State Significant Development Application and Variation of the Sydney Cove Redevelopment Scheme for the “*Remediation, Renewal and Adaptive Re-Use of Campbell's Stores*”, The Rocks (SSD 7056)

Re: Remediation, Renewal and Adaptive Re-Use of Campbell's Stores, The Rocks. SSD 7056

DIAGRAM SHOWING Proposed envelope of Bay 12 with relevant RL's

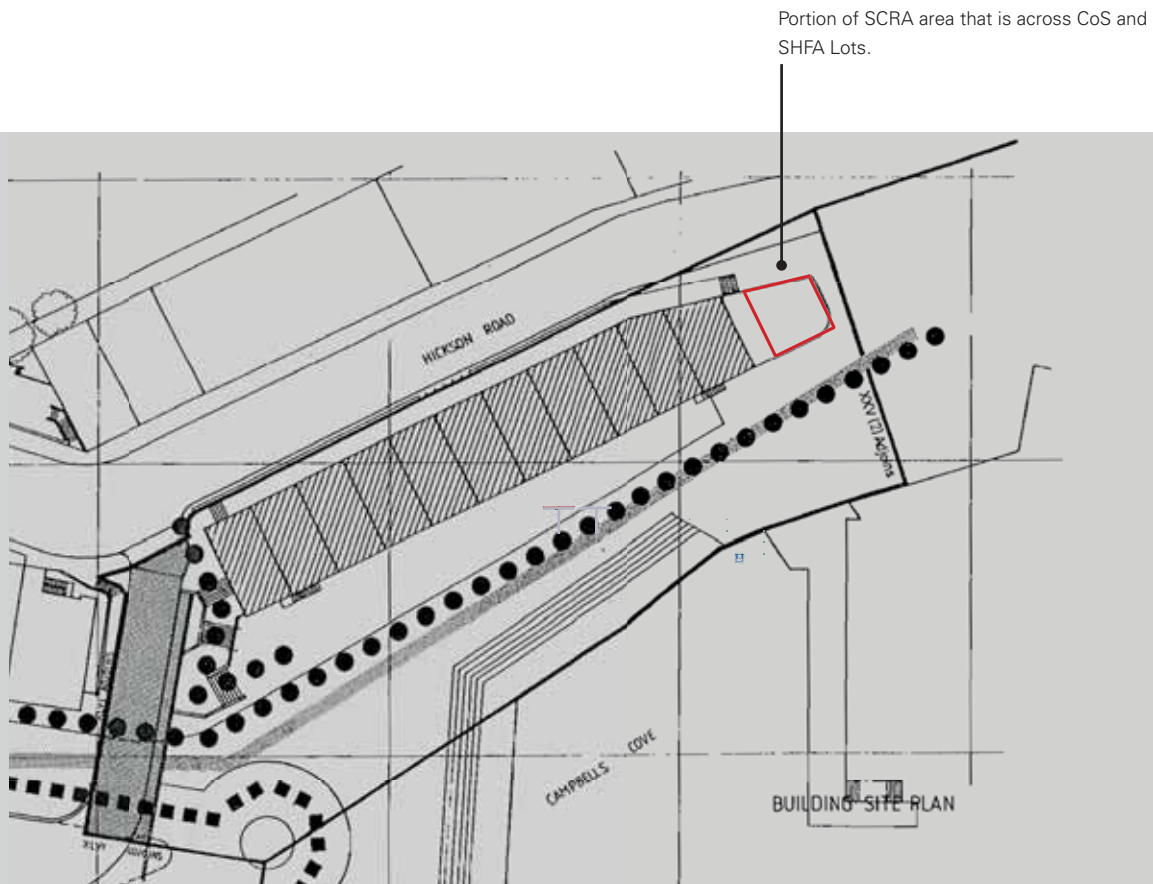
- The proposed new glass building does not comply with the current height limit and the applicant has applied for a "spot rezoning" to increase the height along the waterfront by more than five times the current permissible height limit - from RL3.5 to RL18.

- The proposal exceeds the height restriction on the foreshore **frontage by 14.5m, more than 250% and on the Hickson Road elevation by 10.5m, or 140%.**

Drawing Title  
**ELEVATIONS**  
JPW Project Number  
12006  
Drawing Status  
EA  
Drawing Number  
EA-A-2000  
Revision  
B

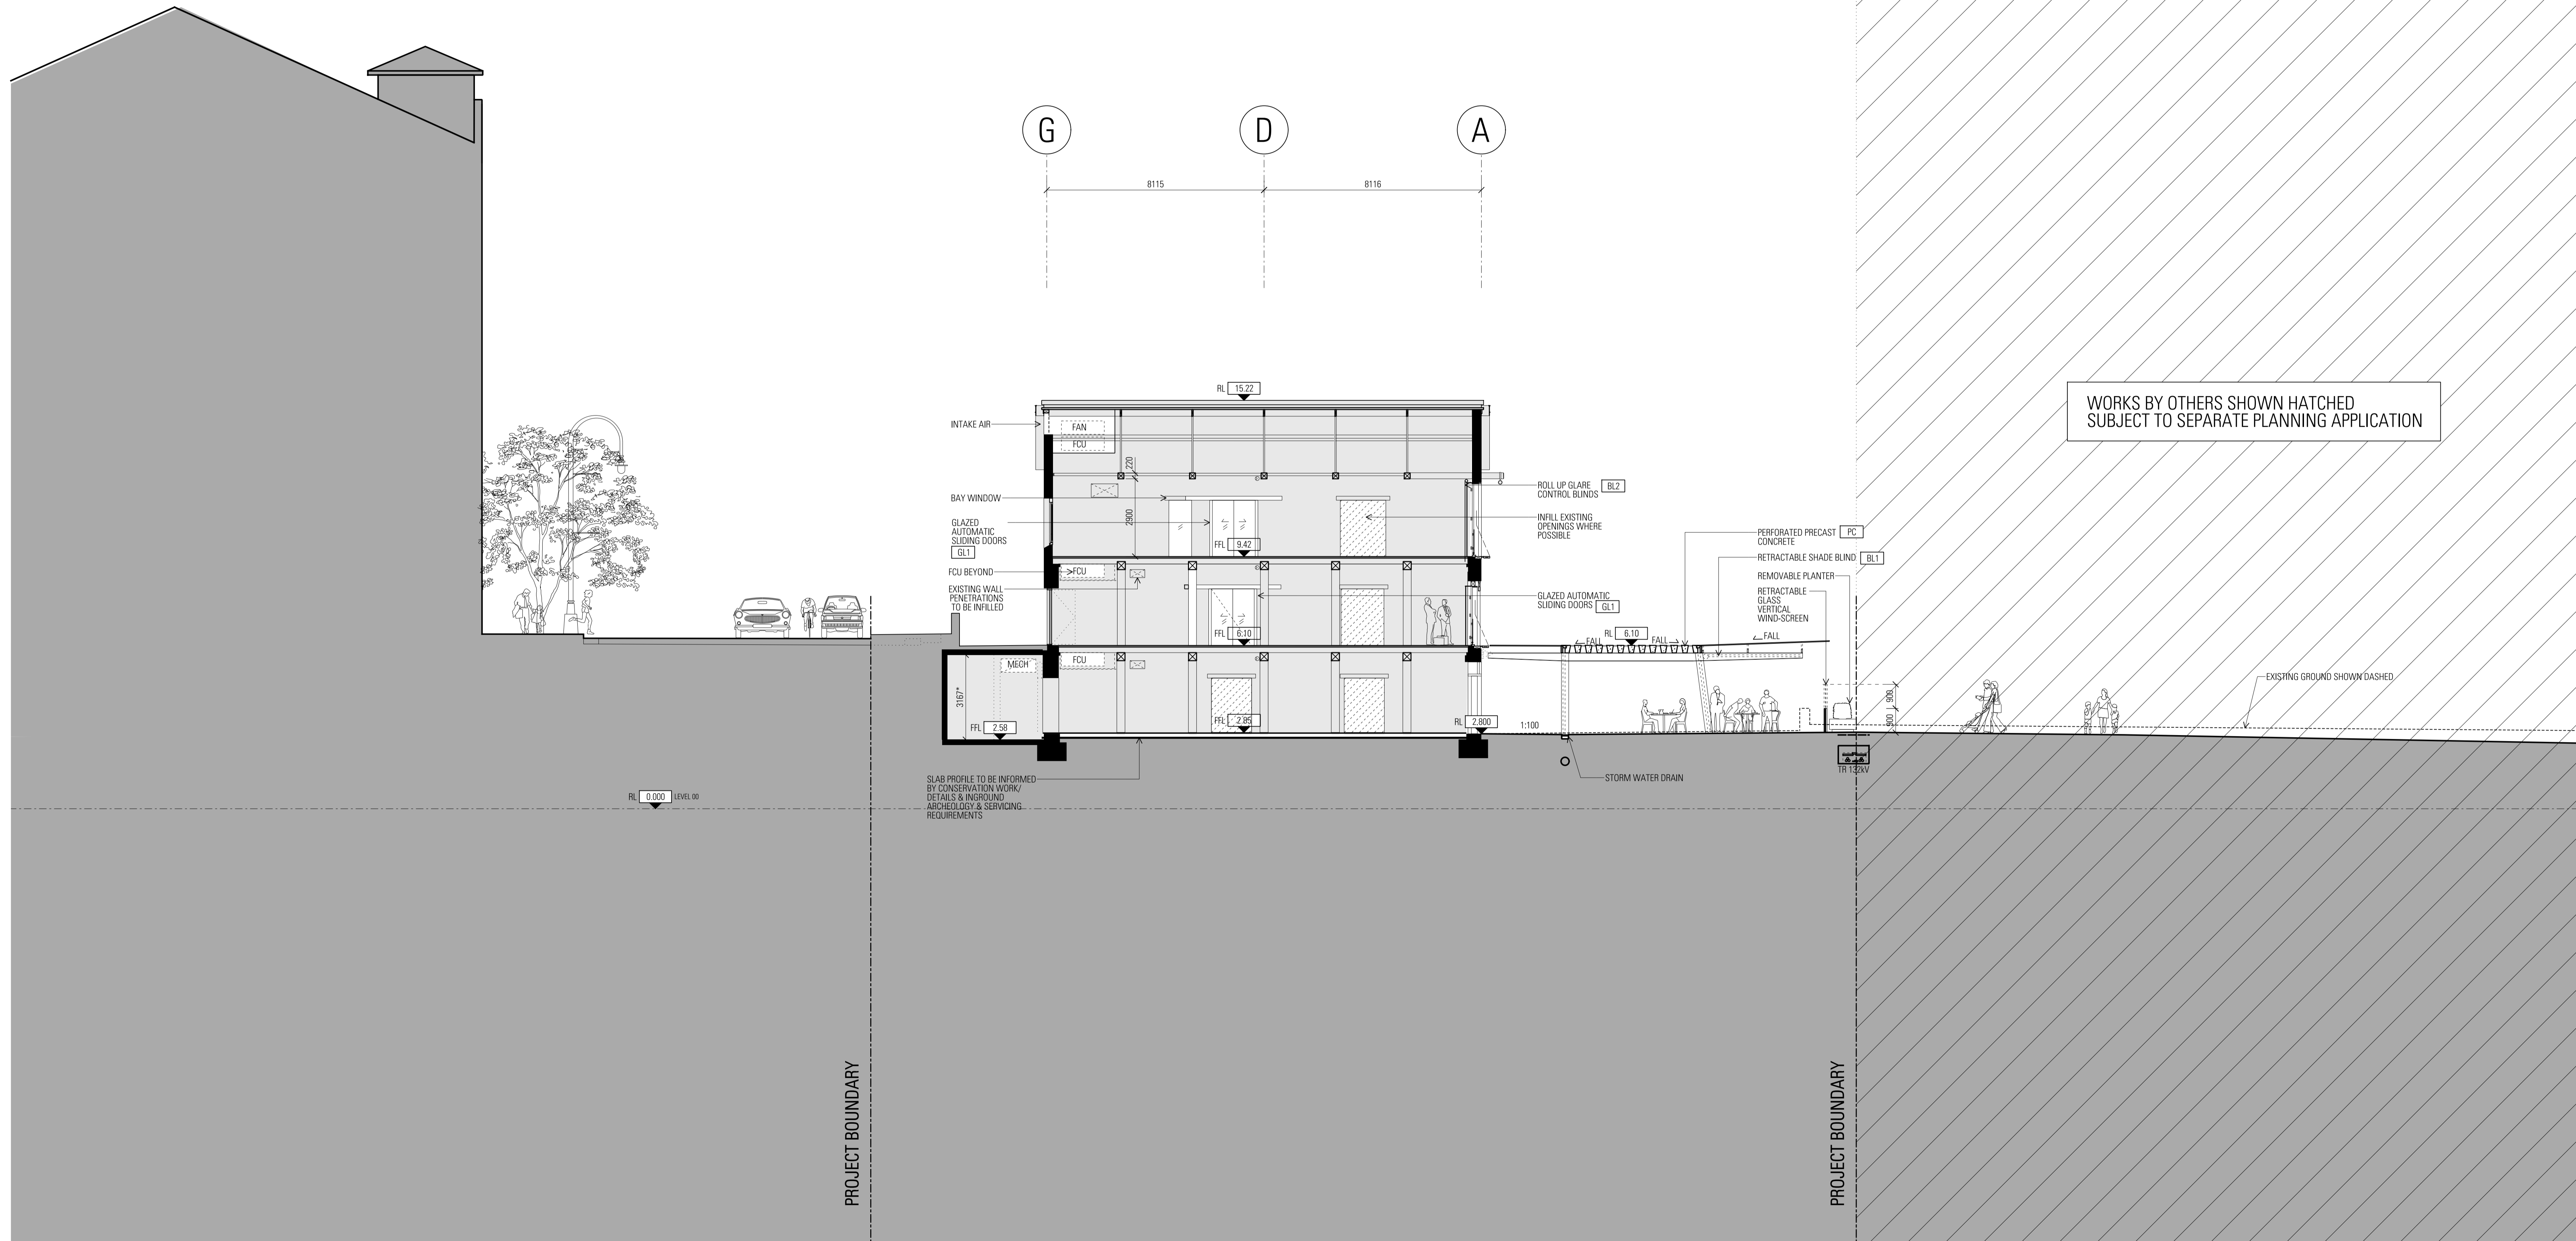
I object to the proposed development, particularly the appropriateness and design of a new four storey glass box to the north of the Campbell's Stores. This is an intrusive and ill-conceived structure that will have negative visual impact and result in the loss of public open space. The proposed new four storey glass building is out of context, dwarfs the heritage building and will be the tallest built element along this promenade. It is located within the buffer zone of the World Heritage Listed Sydney Opera House.

Therefore, **I object to the proposed development**, particularly the proposed new four (4) storey glass building to the north of Bay 11 and the lack of detail in the application to appropriately assess the proposed works to a State listed heritage item.
